Ribble Valley Borough Council
Council Offices
Church Walk,
Clitheroe
Lancashire
BB7 2RA

Phone: 0300 123 6780
Email: developeras@lancashire.gov.uk
Your ref: 3/2025/0836
Our ref: 3/2025/0836/HDC/KW
Date: 30 October 2025

Location: 2 Harewood Avenue Simonstone BB12 7JB
Proposal: Proposed two-storey side extension to extend existing bedrooms and bathroom at first floor and new roof canopy to the front.
Grid Ref: 377111 434587

PROPOSED SITE PLAN
SCALE 1:100

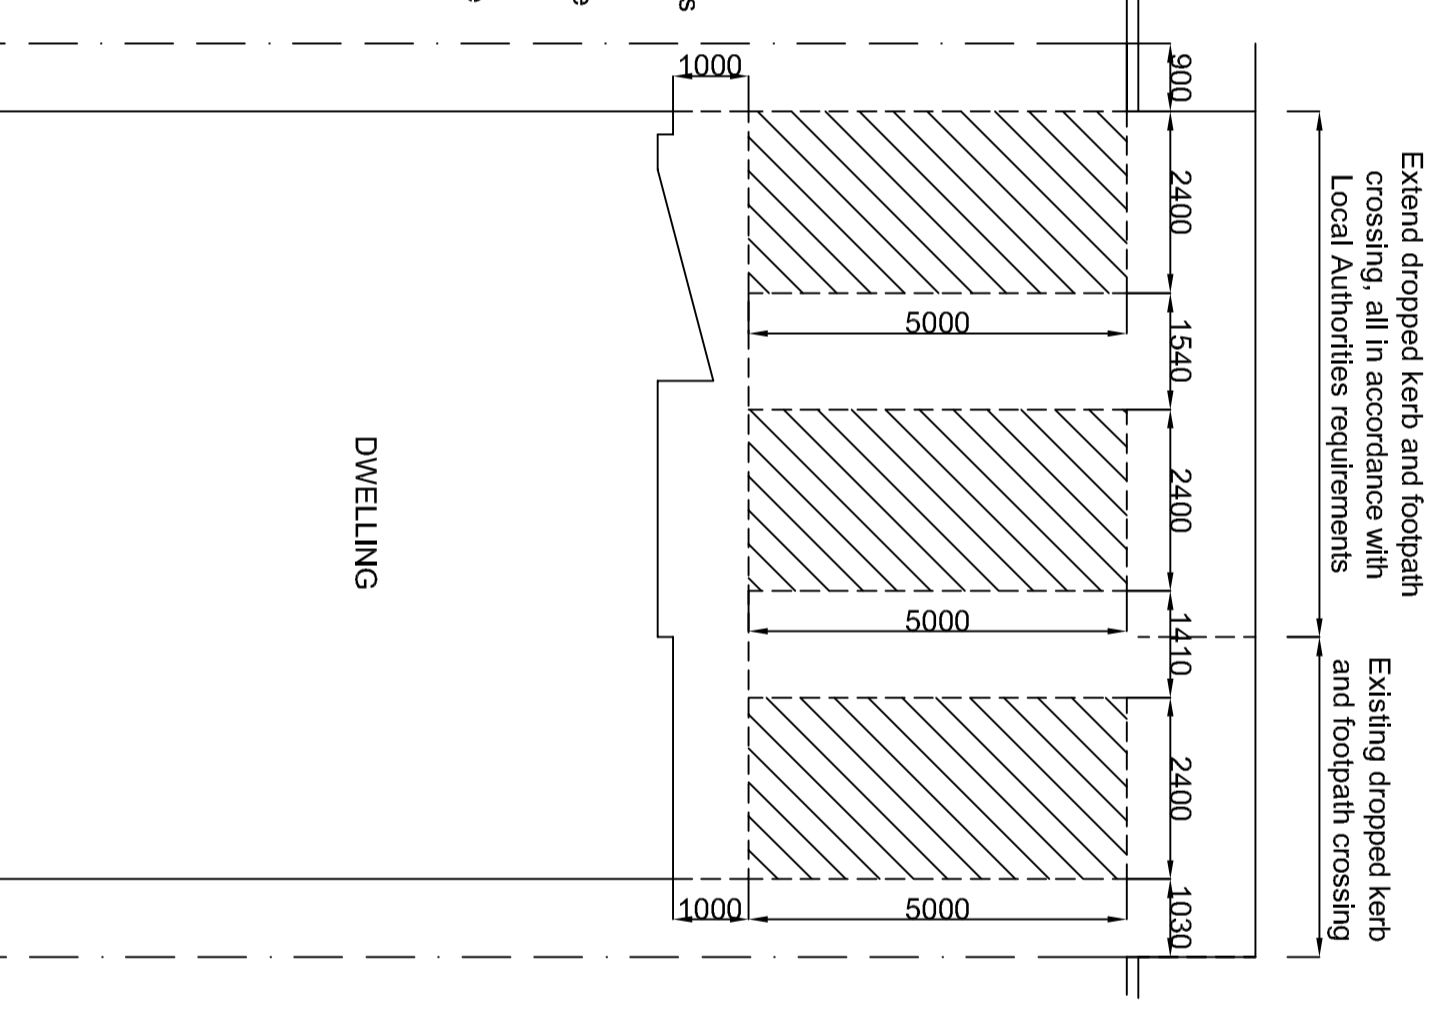
The LHA have reviewed drawing number H.A2/4 titled Proposed Site Plan and are aware that the dwelling will remove the current parking provision within the existing garage and the existing driveway will be reduced in size to 4.6m long, which is not an appropriate length to provide off-street parking provisions as such the LHA would not support the proposal as it is currently presented.

The applicant should provide a detailed dimensional parking plan showing 3 off-street parking spaces within the site in line with the parking standards as described above.
